Substitute Consent Application Ref. ABP-319218-24  
Athgarrett, Philipstown & Redbog, Co. Kildare

I refer to your letter of the 10/04/24 inviting the Planning Authority to make a submission in relation to a Substitute Consent application to the Board. The Planning Authority's comments are set out below.

Figure 12-1 - Site location plan showing haul route.

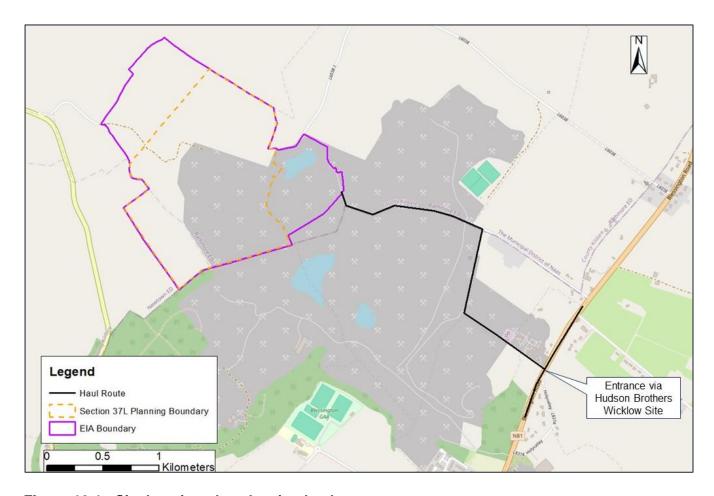
The main access route for all traffic arriving and departing the proposed site would be via the existing access road junction with the N81. It would appear that no improvement works are proposed to this access road and inadequate information has been submitted to confirm as to whether it has been assessed for suitability.

The applicant will be aware, having attending meetings with Wicklow County Council as recently as early 2023, that the section of the N81 between the subject site access point and the Dublin County boundary, requires significant cleaning maintenance largely because of HGV traffic from the quarrying industry. The application sets out that almost 79% of the proposed traffic from the site will use that section of the N81 route for both inward and outward journeys.

The significant of debris deposition issues on the N81 can be directly attributed to wheel borne debris and dust from HGV vehicles within the area and specifically from poorly maintained access roads that are subjected to large HGV numbers travelling over unsealed road surfaces prior to accessing the N81. For this reason the condition and form of the access road from the N81 to the subject quarry is vitally important. The current scenario on the access road is significantly impacting on the effectiveness of the existing on-site wheel wash system. Failure to consider the design and suitability of the access road as part of this application is a significant omission. The proposed development would intensify and likely worsen the issue for all road users of the N81 and local roads in the vicinity.

Where the Board is minded to grant substitute consent, the Planning Authority would request that, the Board attach conditions in relation to, 1) the sealing and surfacing of the access road from the

N81 in accordance with the requirements of the Road Authority, 2) the submission of a Construction and Traffic Management Plan to be agreed with the Planning Authorities, i.e. Kildare & Wicklow County Councils, which shall include for the regular inspection and cleaning of the access road from the N81, and 3) the erection of warning signage on the approach to proposed entrance in accordance with the requirements of the Road Authority, in addition to the standard planning conditions applicable to a large quarry.
